**RE: Request for Further Information
Lingard Private Hospital Expansion (SSD-60316710)**

This letter is submitted to the Department of Department of Planning, Housing and Infrastructure in response to the Request for Further Information (RFI) issued on 10 December 2024, relating to SSD-60316710 for the proposed expansion of the Lingard Private Hospital.

1 21 JUNE 9AM - EXISTING
DA-201 Scale 1:500

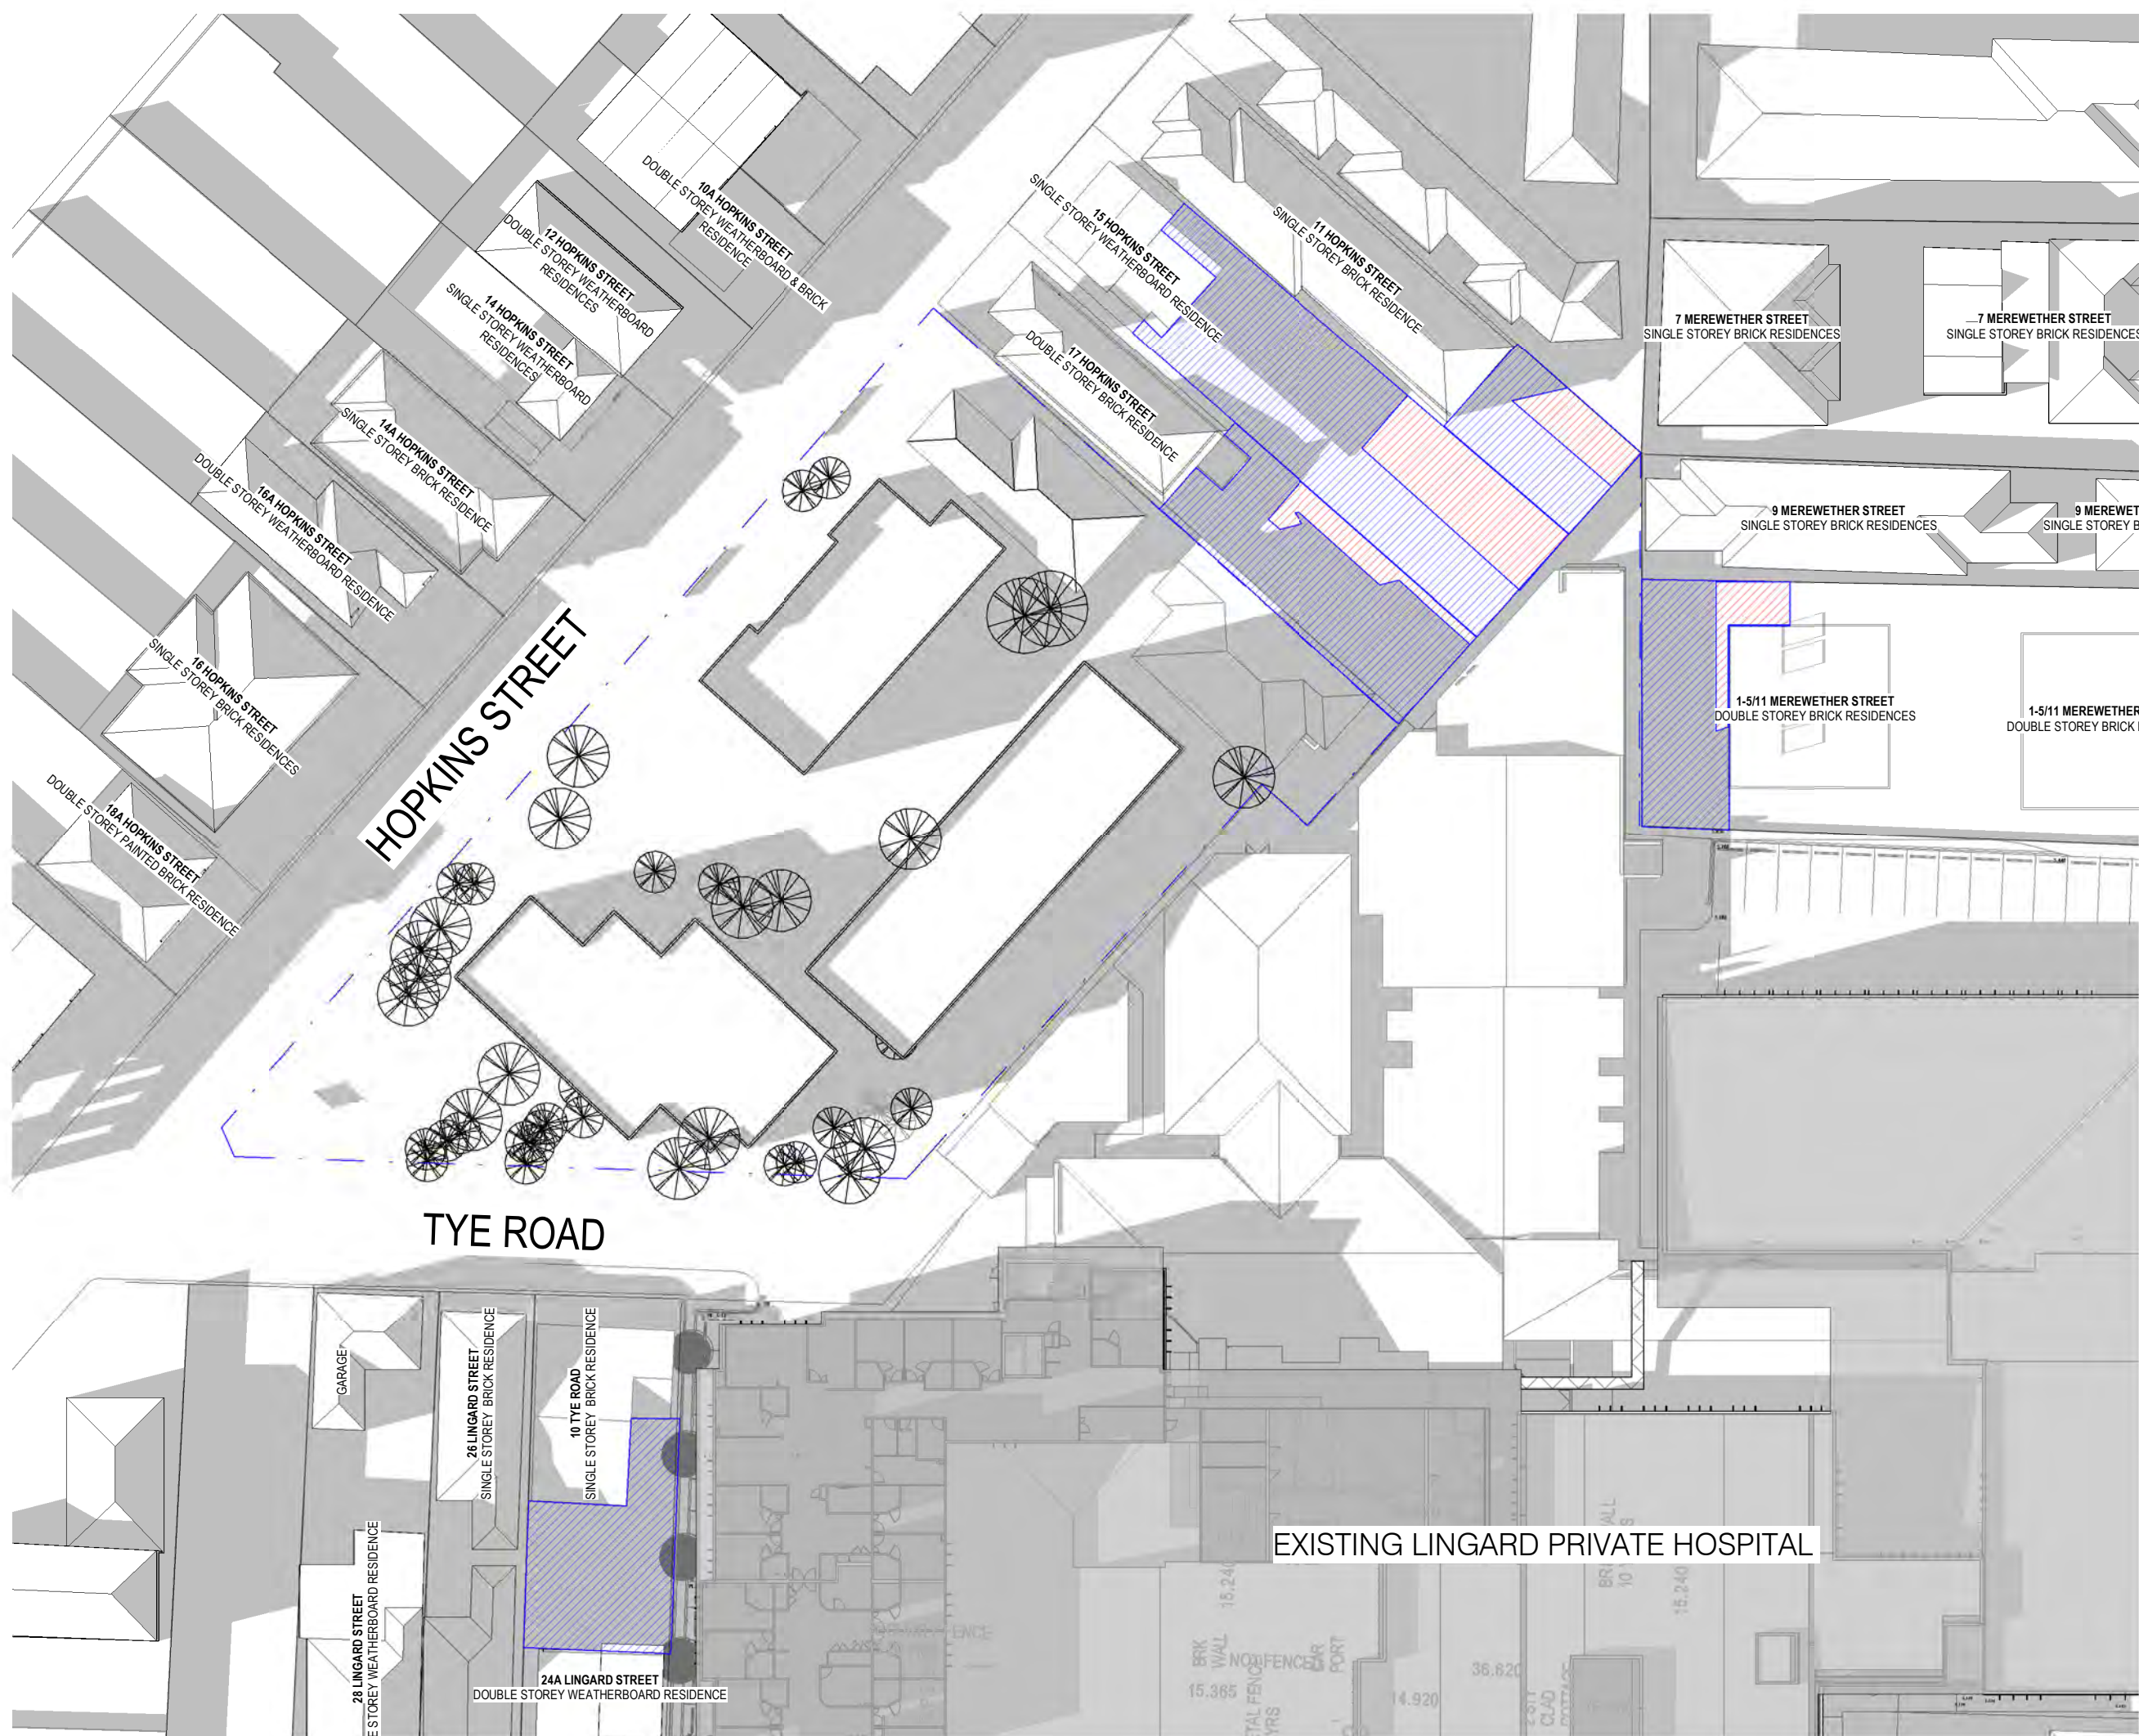
CN's concerns regarding residential amenity remain. The amended architectural plans do not include hourly shadow diagrams or 3D shadow analysis to identify the habitable rooms and private open space of residential properties, as previously requested. The shadow impact to Mitchell Park has not been adequately addressed.

The non-compliant height coupled with reduced setbacks on the eastern boundary of the Hopkins Precinct, exacerbate the amenity impacts. CN recommends the design is amended to reduce the bulk and ensure upper floor levels comply with the setback requirements and maximum building height development standard. CN recommends the applicant is required to submit additional shadow diagrams at hour intervals between 9am and 3pm during the June 21 winter solstice.

Additional shadow diagrams have been provided at Appendix A. The overshadowing of Mitchell Park is minimal, occurring only at 9 AM during winter. The affected area consists of large trees and on-street parking that would naturally be in shadow. The proposal ensures ample daylight reaches the trees and surrounding area at all other times.

The amended shadow diagrams include percentage calculations for the surrounding residential dwellings and confirm compliance. The most significant impact is on 11 Merewether Street in the afternoon; however, the existing shadow diagrams show that this is also the present state, refer to Figure 1 & 2 below. In the previous iteration of plans the second level wall was also setback further from this boundary.

The proposal does affect the adjoining Hopkins Street dwellings at 3 PM; however, there is no impact during the morning hours. The proposed setbacks are consistent with the existing dwelling setbacks in the area. While there is some overshadowing in the afternoon, the dwellings receive sufficient sunlight in the morning,
